ExQ2: 03 August 2021**Responses due by Deadline 7: 03 September 2021**

ExQ2	Question to:	Question:
Bio.2	Biodiversity and ecology, terrestrial and marine	
Part 1 – Matters to be dealt with in writing following ISH7 – wet woodland		
Bio.2.0	The Applicant	Wet Woodland. Please will the Applicant set out briefly what wet woodland compensation it proposes and its location, especially where combined with Fen Meadow compensation
Bio.2.1	Natural England, ESC, SCC	Please will Natural England, ESC and SCC set out their views on (a) the need and reasons for wet woodland compensation and (b) any concerns they have over establishing wet woodland
Bio.2.2	Applicant, Natural England, RSPB/SWT	In relation to both fen meadow and wet woodland why should clearance (and therefore effects) be permitted before the fully functioning establishment of the compensation? The ExA notes this issue is raised by both Natural England and the RSPB/SWT.
Part 2 – Matters to be dealt with in writing following ISH7 – protected species

**Plate 1: Location of new wetlands**

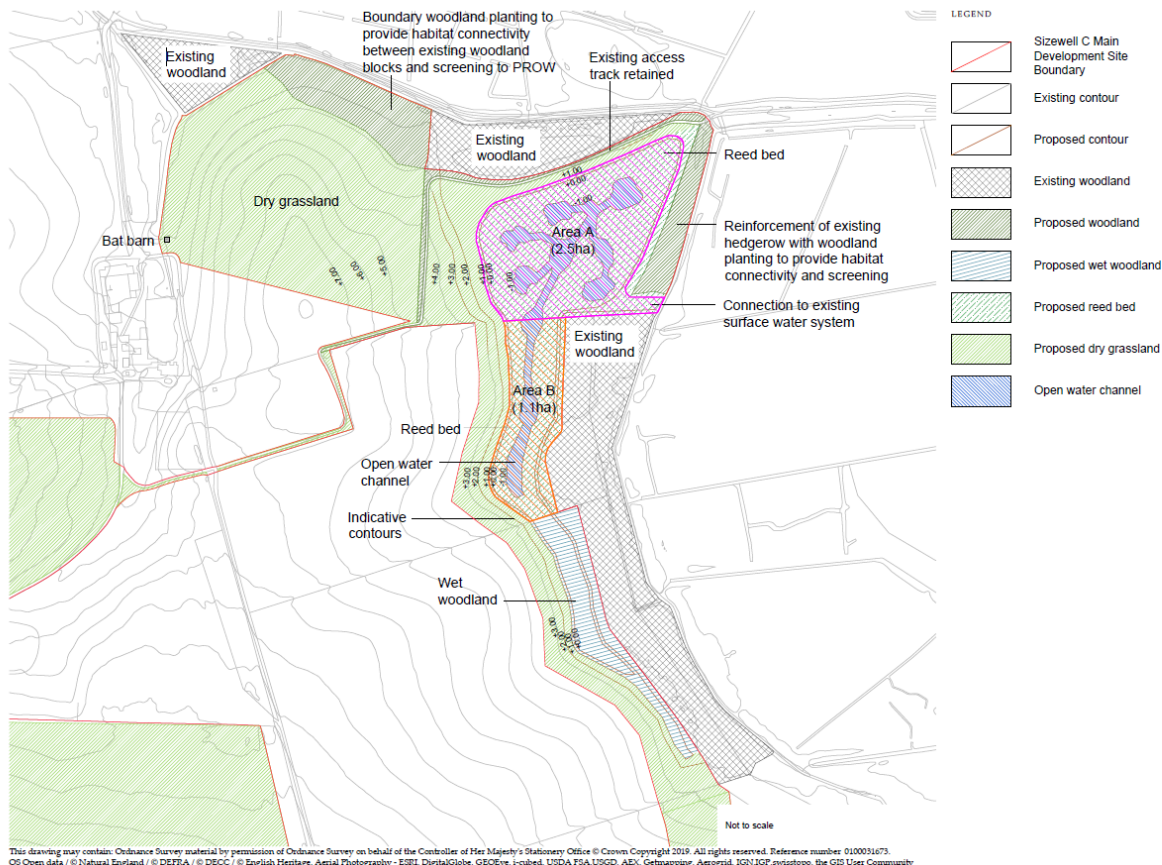
Bio.2.17	Applicant	Bio.1.50. (i) The Wet Woodland Strategy [REP1-020] explains that the loss of wet woodland habitat from the Sizewell Marshes SSSI would be approx. 3.06ha and that the application proposal was to deliver only 0.7ha of compensatory wet woodland. This would form part of the Upper Abbey Farm marsh harrier habitat improvement area and is stated at para 5.1.10 to be part of the original application. Further wetland in the form of open

ExQ2	Question to:	Question:
		<p>water and reed habitats at the Upper Abbey Wood site formed part of the first change request and that could be transitioned to additional wet woodland of 2.36 ha, but this could not be done until the end of the construction phase (para 5.1.13). Thus, the proposal is to create new wet woodland at Benhall and Pakenham totalling at least 2.36 ha. If that fails, wet woodland would be created after construction at the Upper Abbey Farm area of open water and reed woodland.</p> <p>(ii) What is the Applicant's proposal if Pakenham is not confirmed?</p> <p>(iii) Natural England's D5 submission suggests a wet woodland plan is due. When is the Applicant planning to submit this?</p>
Bio.2.18	Applicant	<p>Bio.1.55. The Applicant's response to the question as to how the recreation and amenity strategy is secured is that the reference should have been to the Rights of Way and Access Strategy and that it is secured as it helps to inform the footpath implementation plans to be submitted under Art 15(1) of the DCO.</p> <p>(a) There is no reference to the Rights of Way and Access Strategy in Art 15; surely there should be.</p> <p>It is also said to "accompany" the ROW Plans, and to have been "carefully incorporated into the design and construction planning" which suggests not only routes but also timing and phasing.</p> <p>(b) In what sense does it "accompany" the ROW Plans and how is that explained in those plans?</p> <p>(c) How can the ExA be confident that the strategy has been incorporated into the design and construction of the proposed development?</p>
